RE: Drainage plan Southerly portion of the Shores development

RE: Morris Manor (formerly called The Shores) and the existing The Shores
planned residential development.

RE: Drainage Report for "The Shores" Addition

I have reviewed the drainage report for "The Shores" and I have the following comments:

GENERAL SITE DATA:
 64 Single Family Dwellings
 11.60 Acres
 9.52 Units/Acre Density
 Present Zoning SU
 Average Lot Size is 55' x 100'

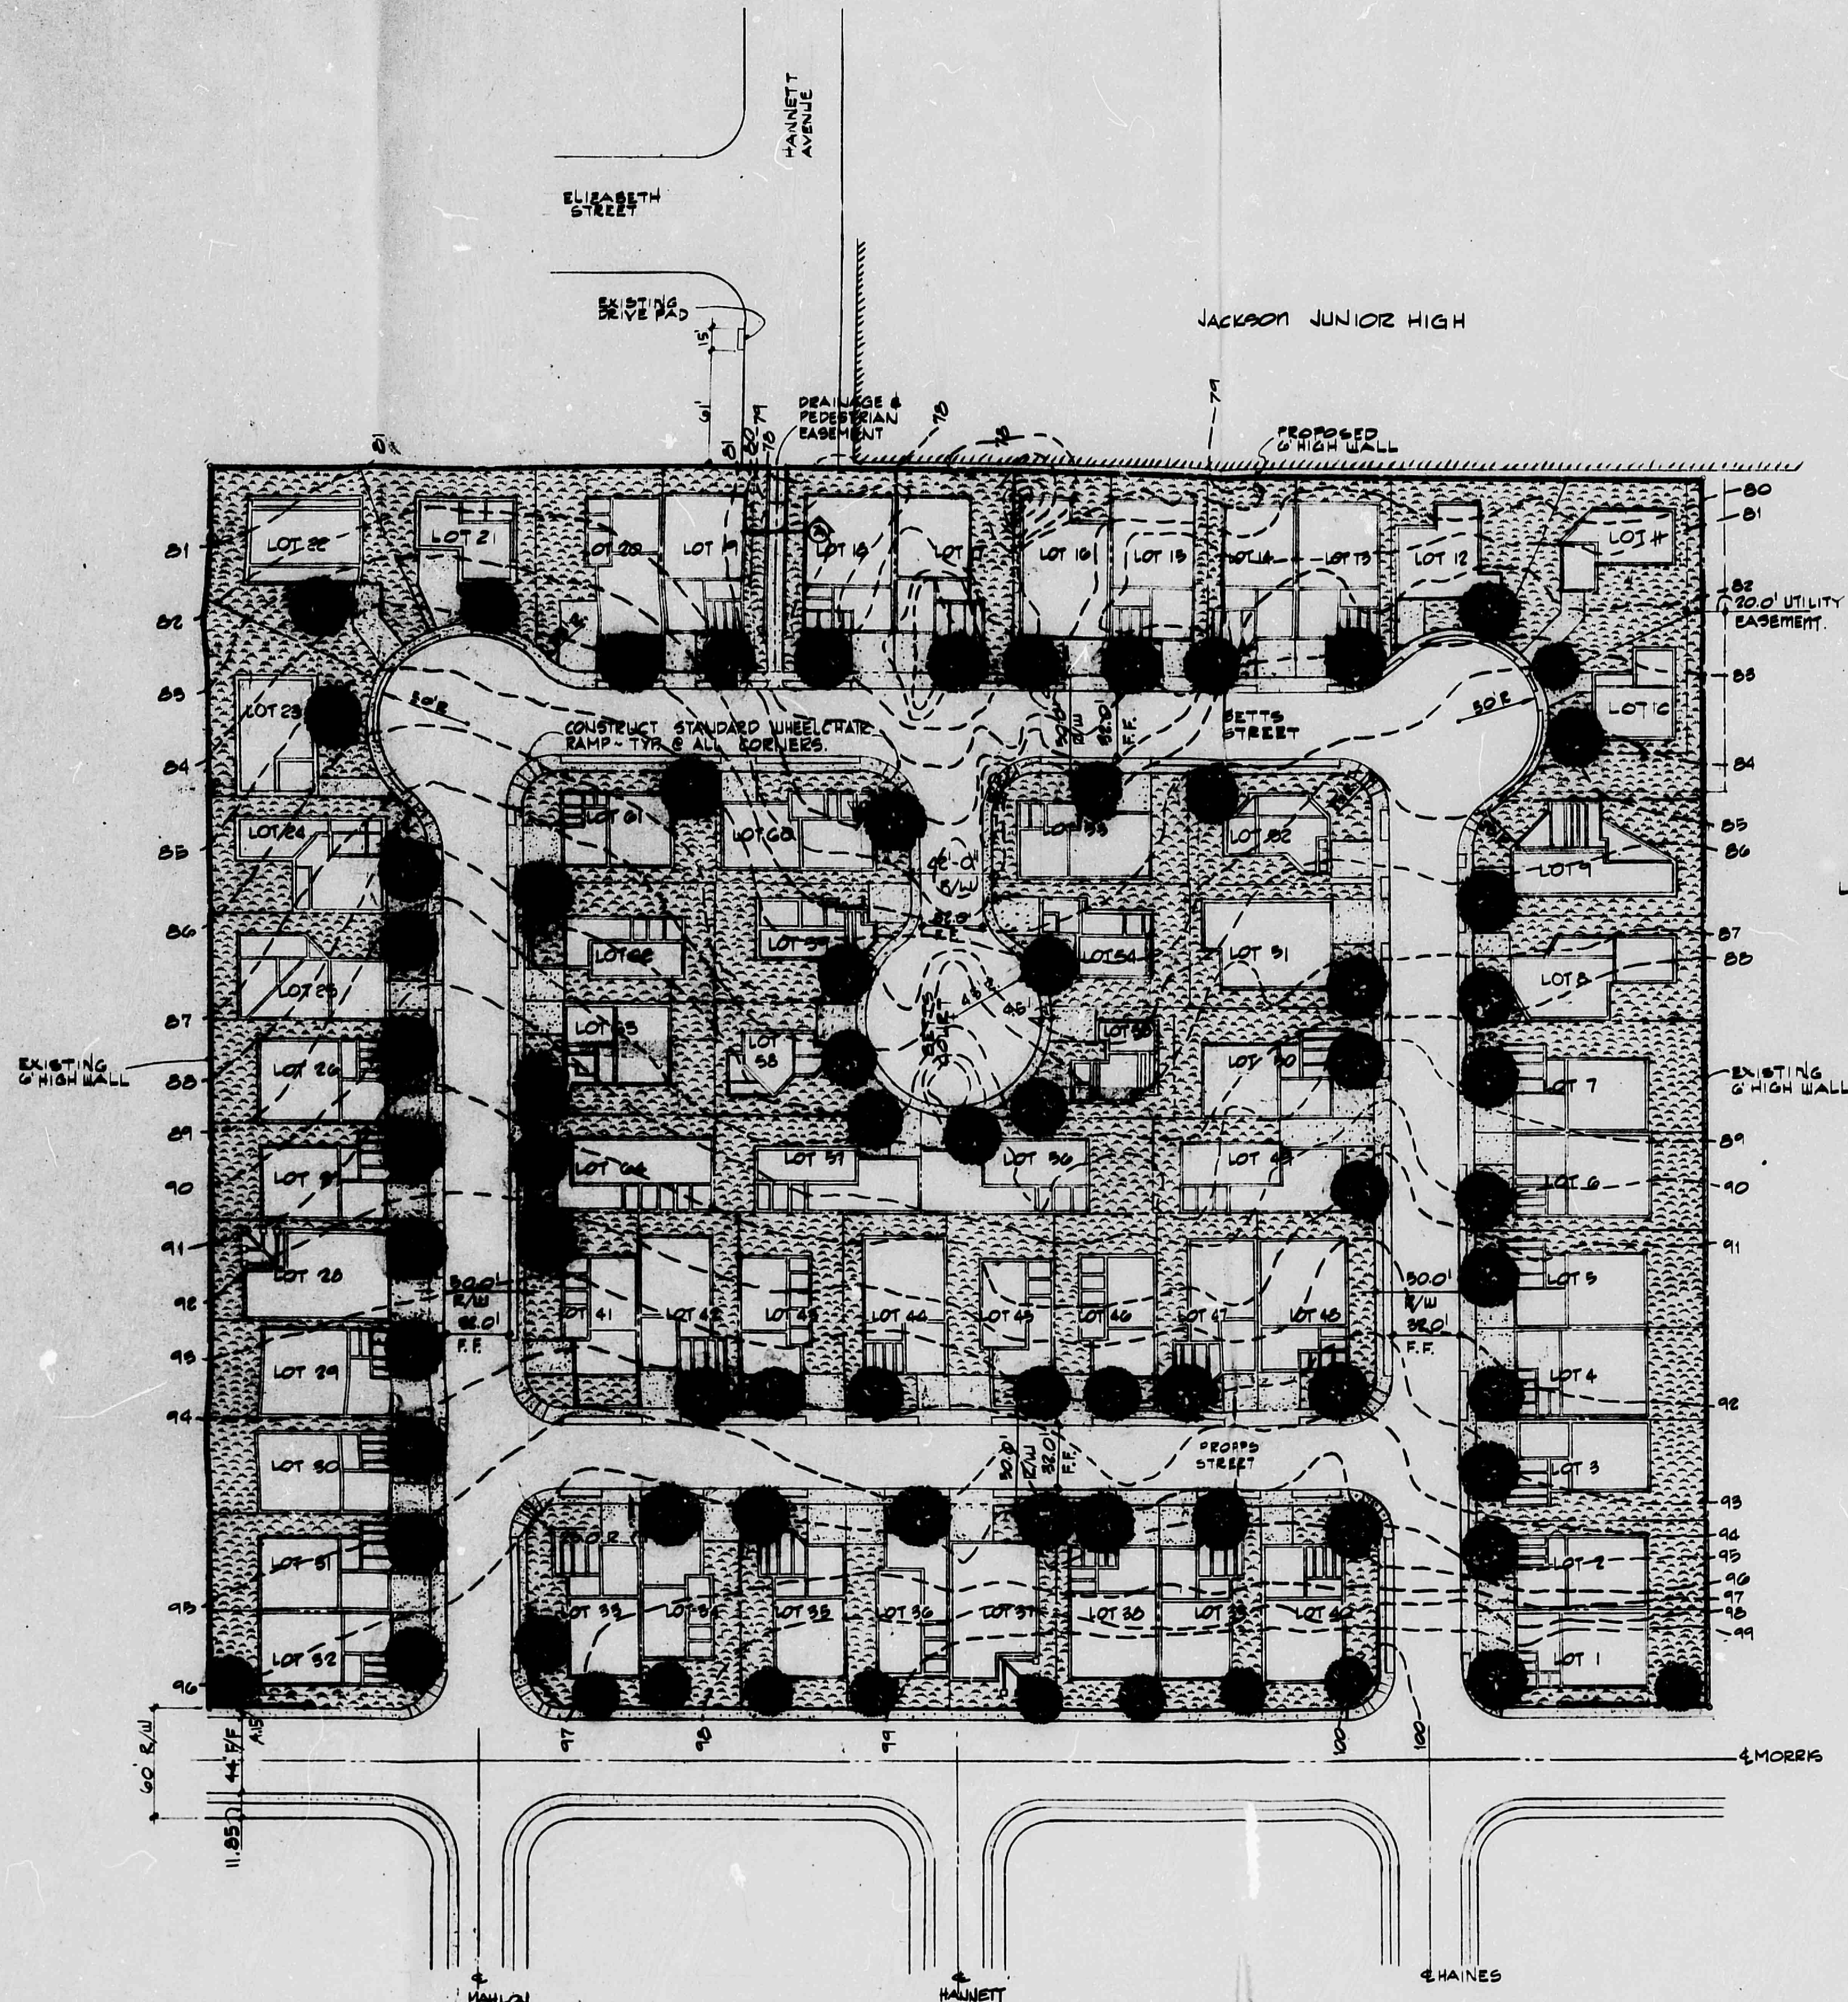
On page 2, the report indicates that "local flows from the Southwest corner of the developed "The Shores" drains into the undeveloped parcel." The existing topography for the proposed development as submitted with the drainage report does not show such offsite flows. Is the statement incorrect or is the topography different from actual conditions? Further, the statement "...it is recommended that this Southwest corner of the developed parcel be regraded to pond runoff on the adjacent development" is very vague. Whom is the recommendation addressed to? Who will perform the recommended regrading? How is the regrading going to be accomplished?

Since several assumptions are made in the computations, particularly in regard to infiltration rates, it is recommended that the finished floor elevations of the buildings be established a minimum of 6 in. above the level of ponding areas.

It is further requested that an appropriate drainage easement be dedicated on the plat and that a standard City of Albuquerque rundown be constructed between lots 18 and 19 of this subdivision.

Grading of the area immediately to the north of Morris Manor will cause all storm runoff to flow in swales parallel to but offset from the base of the proposed six foot high block wall dividing The Shores, Phase I from Morris Manor. The runoff will flow either to the newly constructed ponding area or to the proposed ponding area in the southwest corner of The Shores. The runoff from the roofs and the proposed private roads, driveways, and sidewalks is designed to flow either into the newly constructed ponding area or to the north into Indian School Road via the private road on the west side of The Shores.

In conclusion the site plan for the southwest portion of The Shores, Phase I, the proposed Development Plan for Morris Manor and the proposed Grading Plan for Morris Manor all show a coordinated drainage scheme that will comply with A.M.A.F.C.A., Resolution 1972-2, provided that the southwest portion of The Shores, Phase I is constructed as shown. It is concluded that the proposed development will not create a flood hazard to surrounding properties, nor will the property itself be in danger of flooding.
